**Planning Application Ref:** R/234/19/T

**Location:** Various locations Sea Estate Rustington

**Description of works:** Various works to 3no. macrocarpa trees, 3no. holm oak trees, 1no. black/Austrian Pine tree and 1no Monterey pine tree

SEA ESTATE RUSTINGTON
PROPOSED WORK TO TREES WITH PRESERVATION ORDERS (TPO'S)
2019 - 2020
REFER TO APPLICATION TABLE A FOR SCOPE OF WORKS

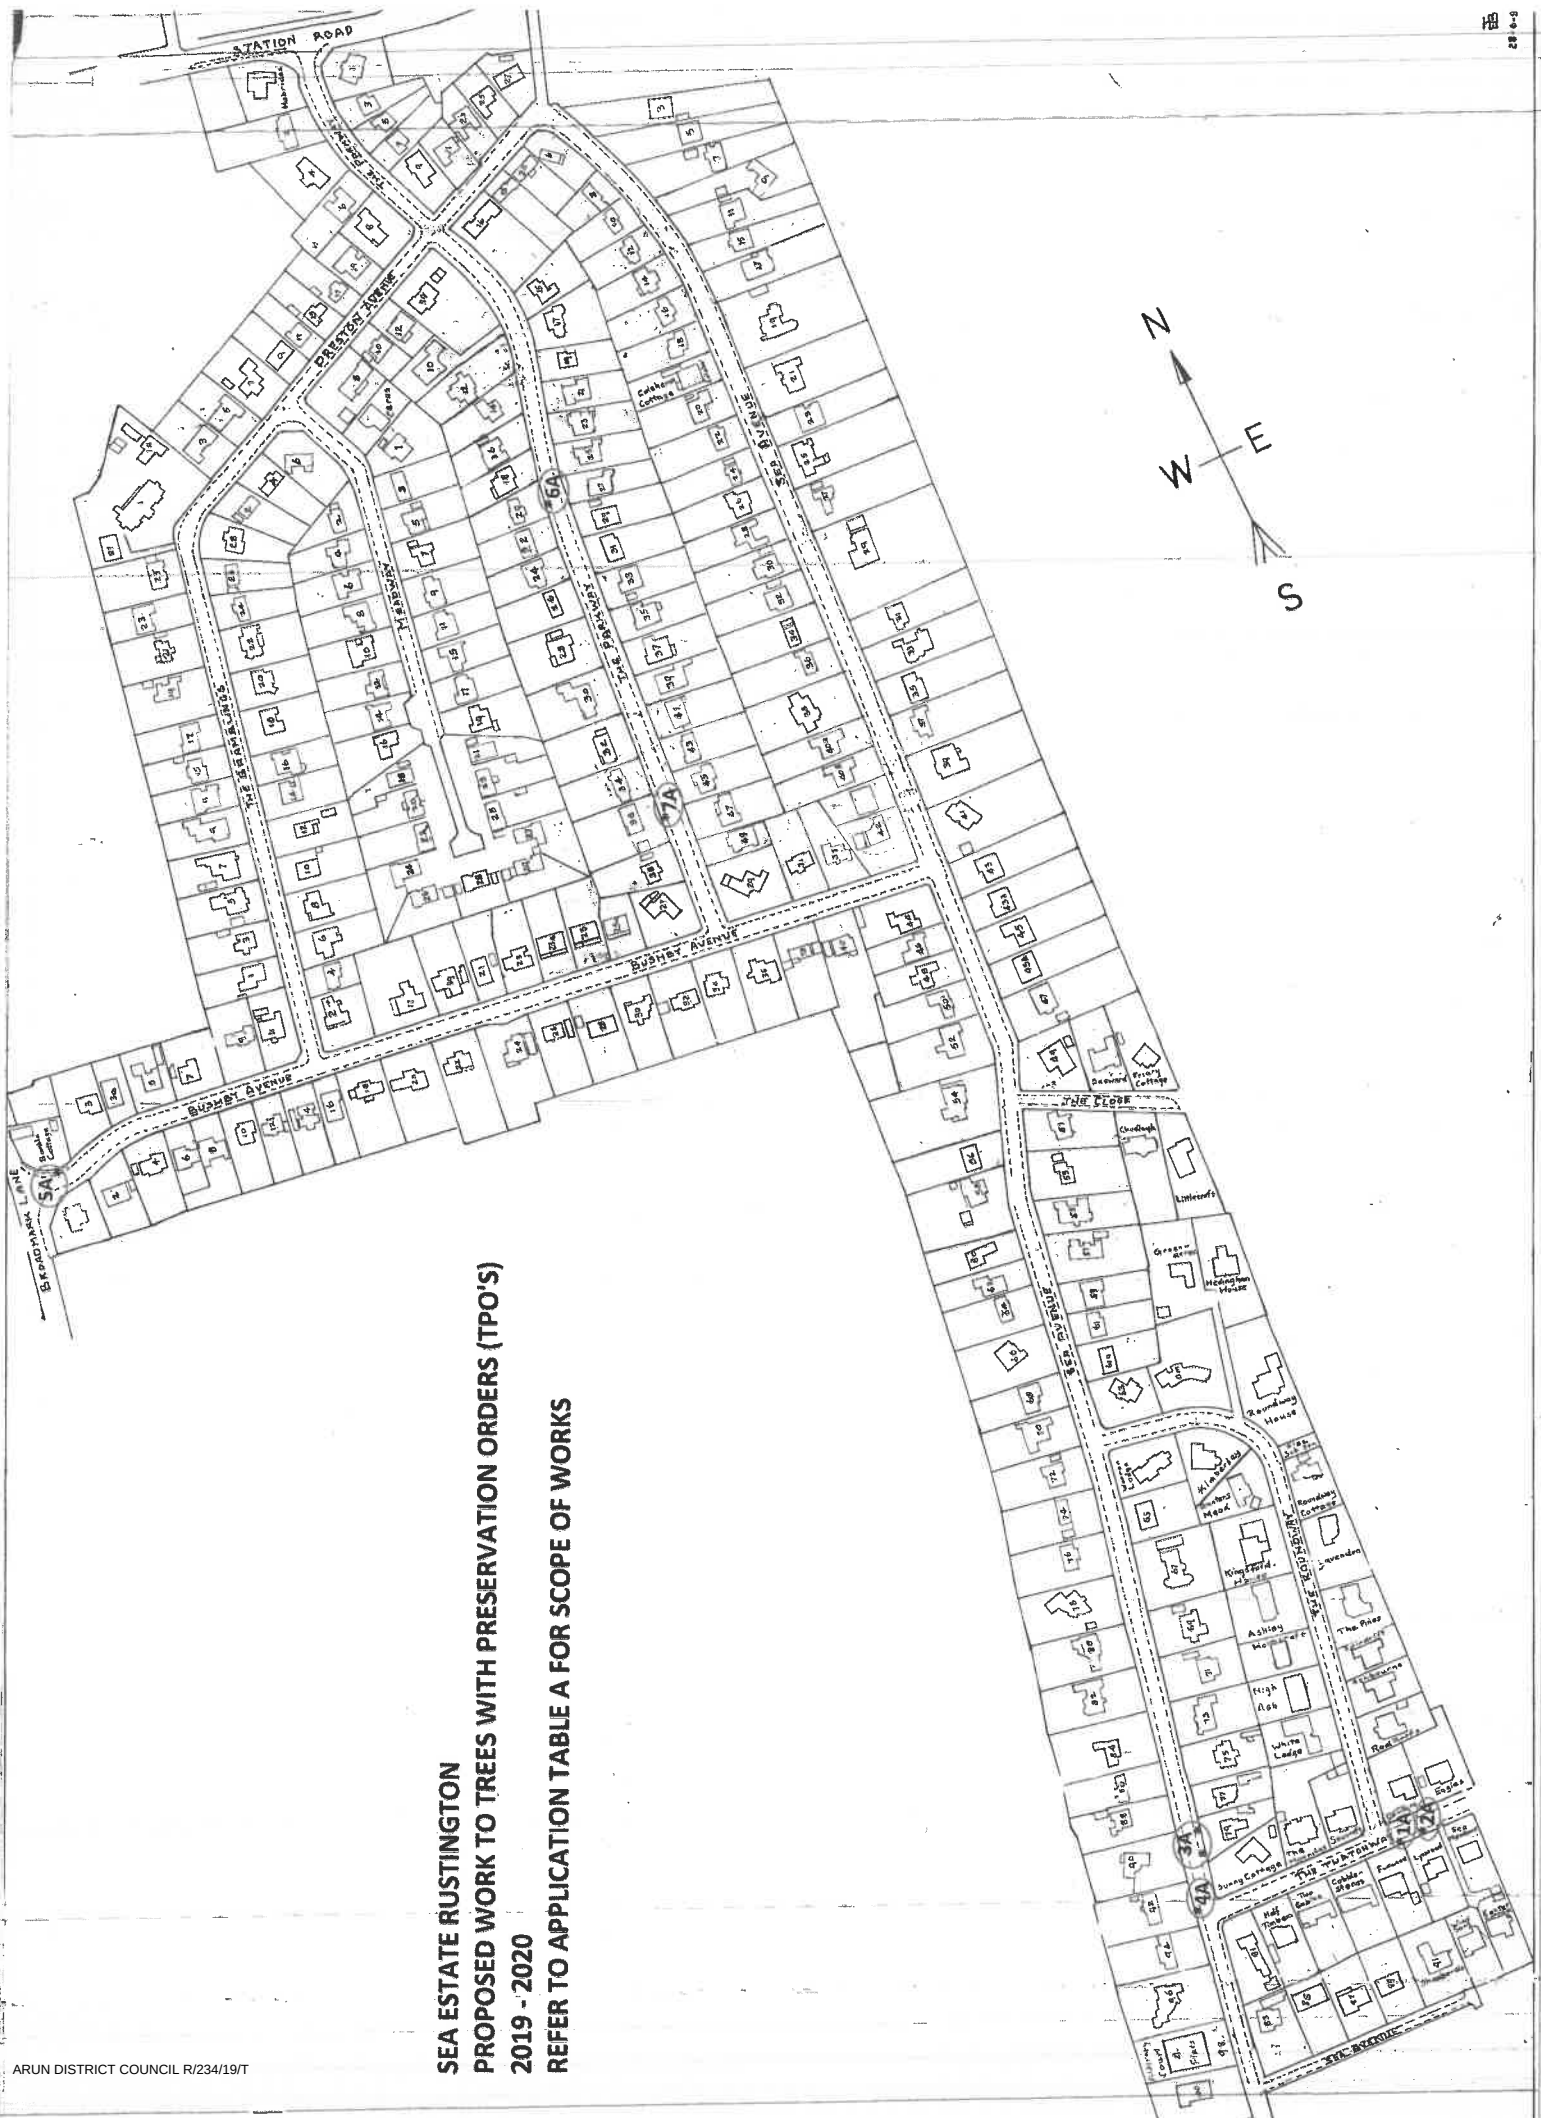
- **1A & 2A** – These are large, mature examples of their type, appearing to be free from obvious structural defect and in fair physiological condition with relatively unmodified and attractive crown profiles. They are heavily exposed to the coastal conditions and enjoy mutual support as companion trees.

- The proposal to reduce both the height and lateral spread on all aspects (the correct interpretation of *crown reduction*) potentially by 3metres respectively would involve the removal of more than two-thirds of their foliar mass. This does not comply with 'British Standard (BS3998:2010) Tree work – Recommendations' and would be likely to result in harm to the health and vitality of the trees with large pruning wounds being formed as well as undermining their visual amenity value and impact in the landscape.

- **3A & 4A** – These are semi/early-mature examples of their type, appearing to be free from obvious structural defect and in fair physiological condition. They have heavily modified crowns displaying a formal and controlled appearance, such that they are unlikely to realise their full potential. These are trees of limited amenity value and as such the work proposed is unlikely to be detrimental to the character of the area, although like all trees they are worthy of respect and any work should be conditioned to a high standard.

- **5A** – One of two companion trees, of mature age and appearing to be in a fair-poor physiological state. An old partially occluded 'hazard beam' (longitudinal split) was noted on the lowest limb tending west. This is one of the limbs proposed for removal and so that hazard can be dealt with in good time as well as ensuring adequate overhead clearance above the footway. The proposed removal of six limbs is excessive and not justified, although there is a requirement for low branches to be pruned clear of garden vegetation to prevent direct suppression and facilitate maintenance.

- **6A** - This is a mature example of its type, appearing to be free from obvious structural defect and in fair physiological condition with a relatively unmodified and attractive crown profile. It is located at the southern end of the property's front boundary, a solitary pine and the obvious candidate for this work, which will involve the removal/reduction only of small diameter branches.

- **7A** - This is a large, mature example of its type, appearing to be free from obvious major structural defect and in fine physiological condition with an attractive crown profile. The work proposed would involve a substantial loss of foliage bearing branches and diminish the tree's visual amenity. It has not been entirely justified on arboricultural grounds. The removal of crossing (subordinate) branches is acceptable. Dead wood removal is an exception and does not require

formal planning consent. The maturing black pine opposite is tolerating and not unduly suppressed by contact with limbs/branches from the much larger tree, although it would be acceptable to shorten the tips of those branches which may cause direct damage to its main stem and limb framework.

- T1A, 2A, 5A and 7A require careful management that adequately respects their age and vulnerability to environmental changes and disease progression. They are all important and prominent constituents of an established population of trees which help define the character of the estate/area and so represent a significant public amenity.

- Although much of the work is well-intentioned, I find the quantity of foliage bearing branches proposed for removal to be excessive and likely to result in detriment to those tree's ongoing health, vitality and visual amenity.

- There is no obvious arboricultural justification for much of the work proposed. While I can sympathise with concern for the size of such large and aged trees in proximity to residential property, the associated inherent risk can be adequately mitigated with a regular programme of inspection by an arboriculturalist - entirely justifiable for such a large population of high amenity value trees many of which are in advanced stage of maturity.

- As it stands, I recommend **REFUSAL** for this application.
- I would like to see the applicant agree to a revision of their work proposals such as I detail below (in bold), which could address some of their concerns whilst preventing a diminution of tree's landscape and public amenity value:

- **1A & 2A**      **Remove items from application.**
  - 3A & 4A      Approve as described.
  - **5A**            **i) Remove lowest west tending limb.**

**ii) Remove small branches (<50mm diameter) as necessary to achieve maximum of 1m clearance above established garden shrubs and hedge plants.**

- 6A            Approve as described.
  - **7A**            **i) Remove crossing (subordinate) limbs to mitigate risk of failure**  
                     **ii) Reduce length (by maximum of 1.5metres) of three limbs, the lowest across north and west aspects, to retard future growth rate but retain enough foliage to sustain themselves.**

Part a) Where whole branches are to be removed and final cuts made close to the trunk or branch union they are to be made as shown in Figure 2 of BS3998:2010

Part b) Where branches are to be shortened back the final cuts are to be made at the correct angle shown in BS3998:2010 and adjacent to a live bud or lateral.
